CITY OF ALBUQUERQUE

Re: Melloy Dodge, 9621 Coors Blvd. NW
Request for Certificate of Occupancy
Transportation Development Final Inspection
Architect's Stamp dated 11-16-16 (B13D019)
Certification dated 8-10-17

Administrative Site Plan

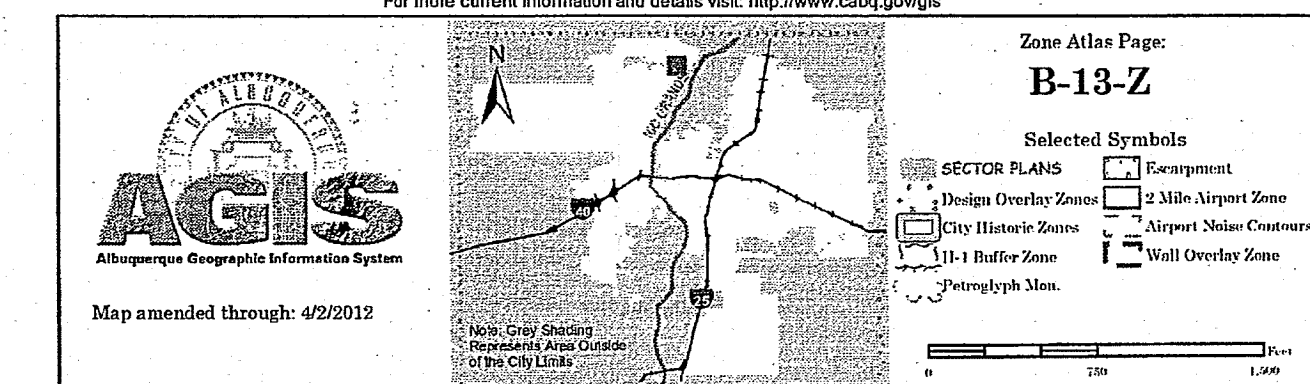
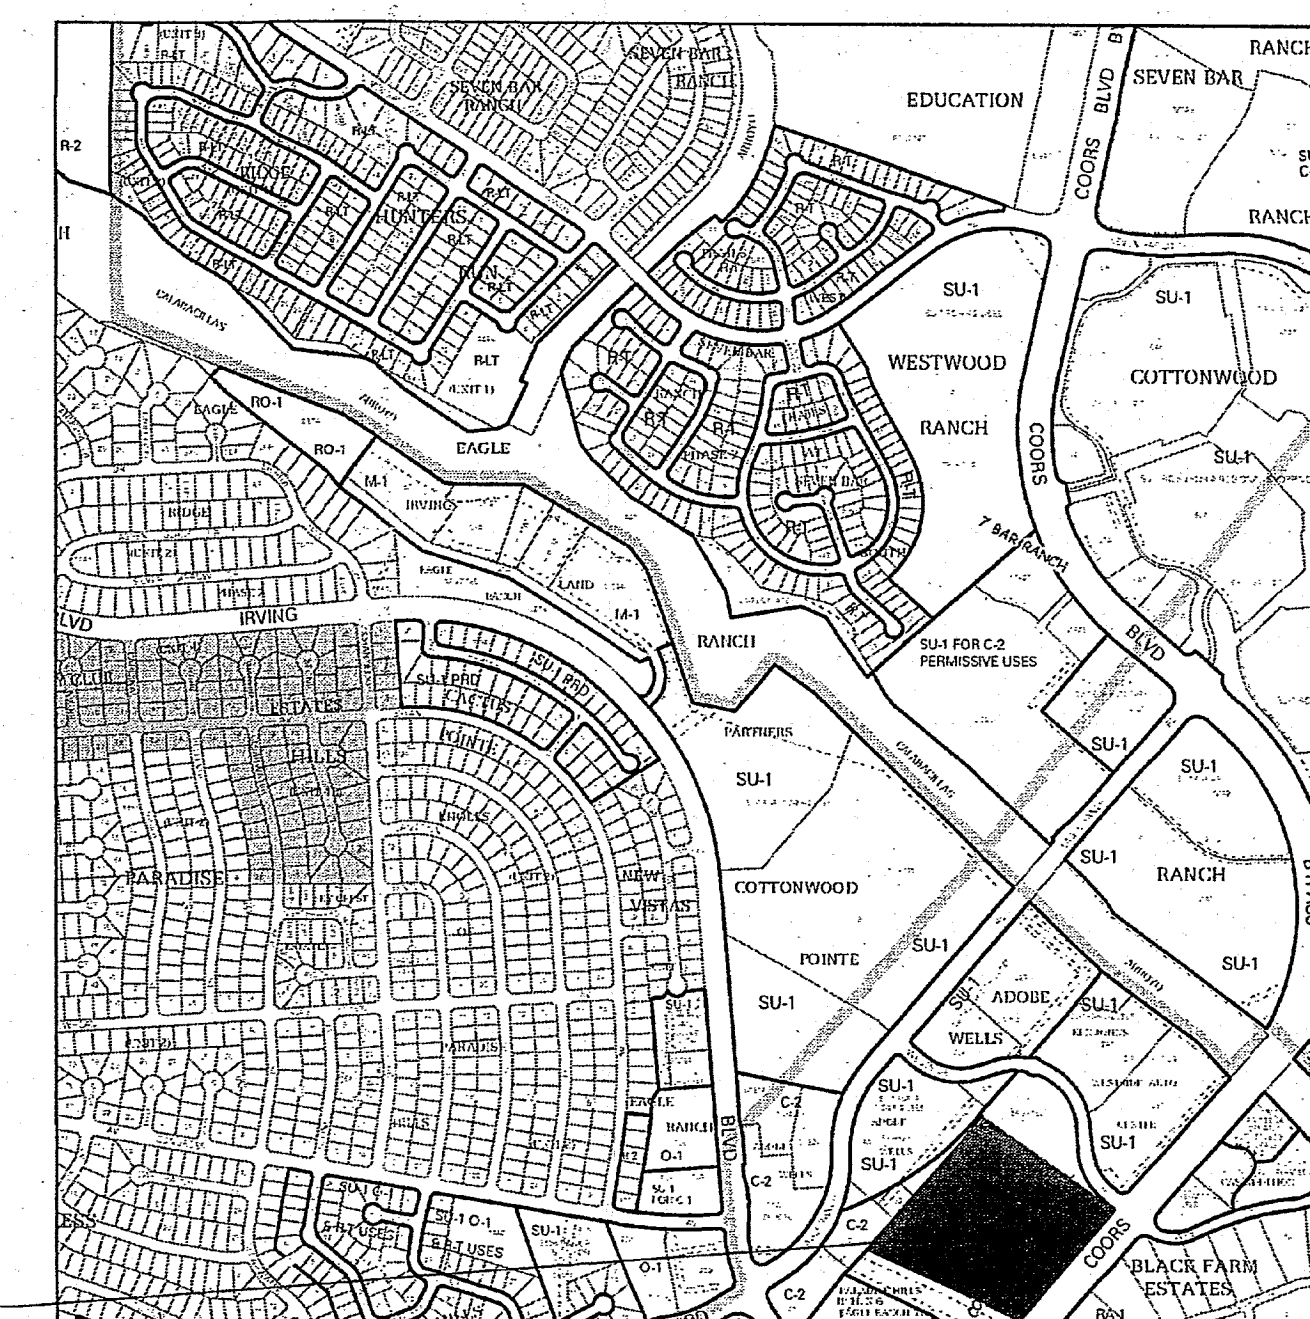
- Please provide updated Administrative Amendment for the new parking spaces
and building addition.
